**Hastings Secondary College Port Macquarie Campus Upgrade (SSD-11920082)
Response to Submissions**

Attachment 1

BOUNDARY 44.97

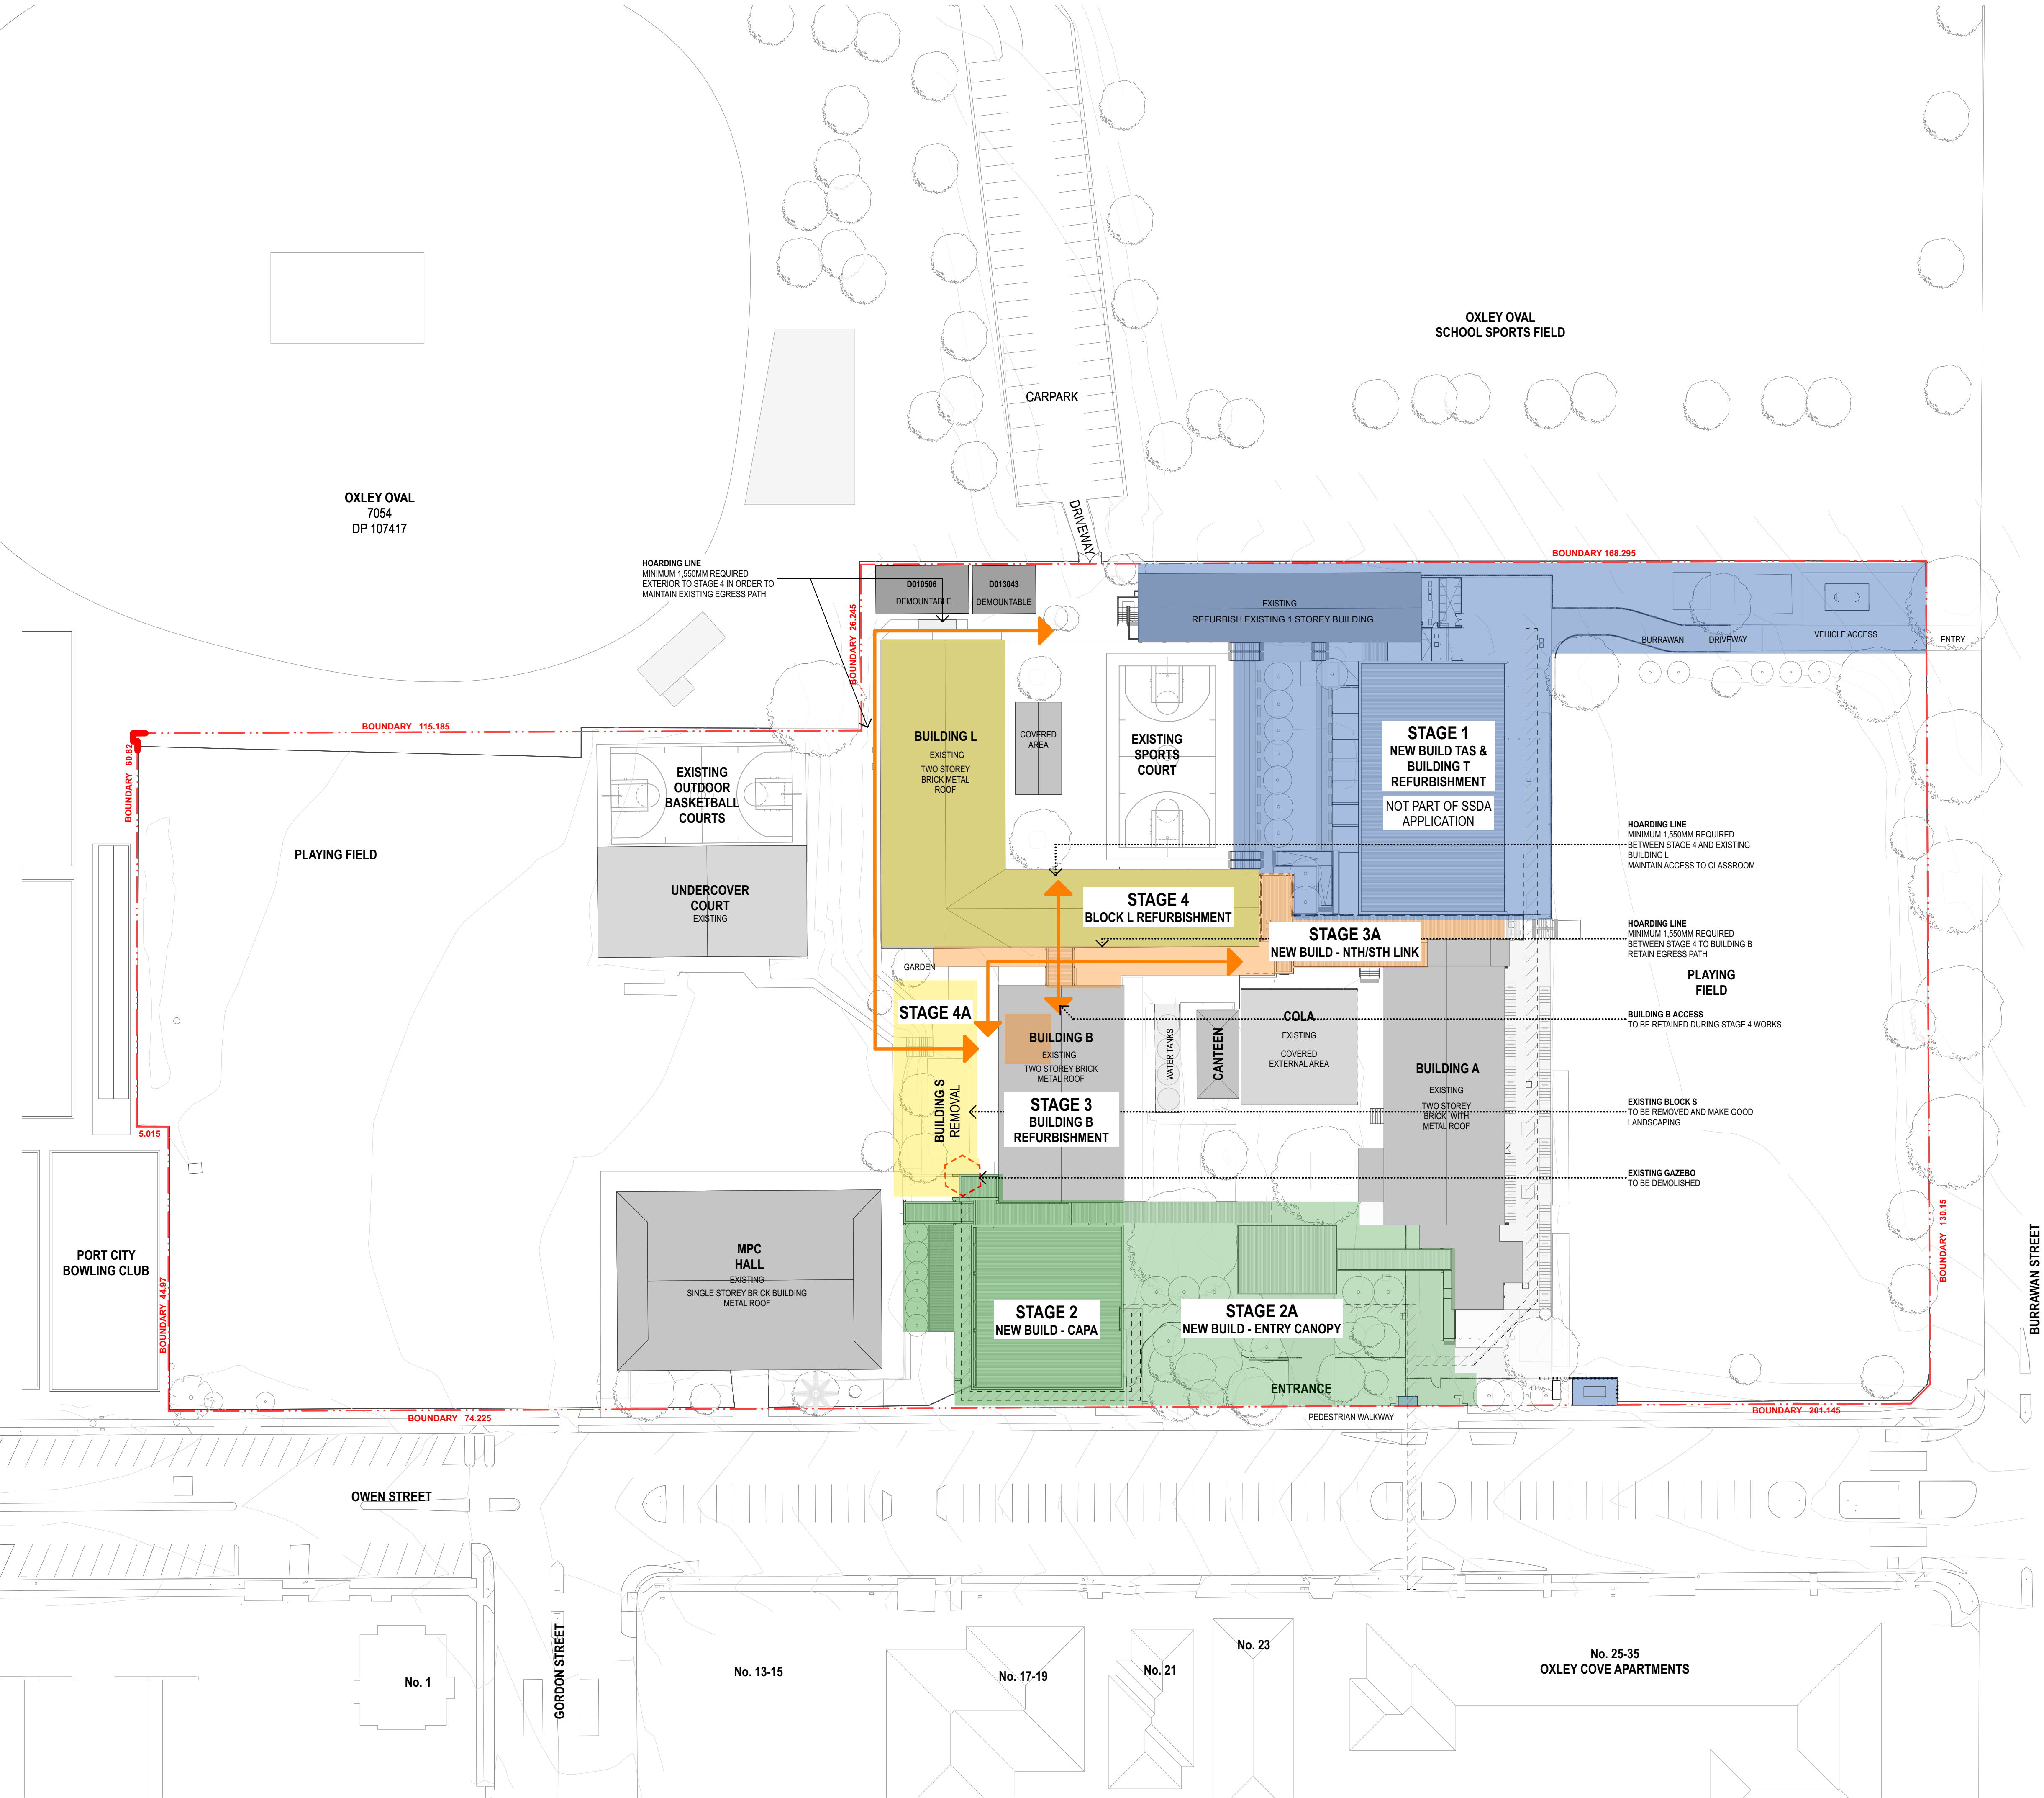
- Further consultation should be undertaken and additional information provided in relation to potential conflicts between continued operation of the school alongside construction activities, including construction traffic. Areas where construction cannot occur (No Go Zones) should be identified along with designated and potentially available construction zone areas. This should be provided to better inform the planning of construction activities and maintaining a quality and safe learning environment for students, teachers and other stakeholders and minimise risks of conflict with construction activities. This information should be shared with consultants engaged in construction management impacts, particularly traffic and noise/vibration, their reports updated and further information provided in the RtS.
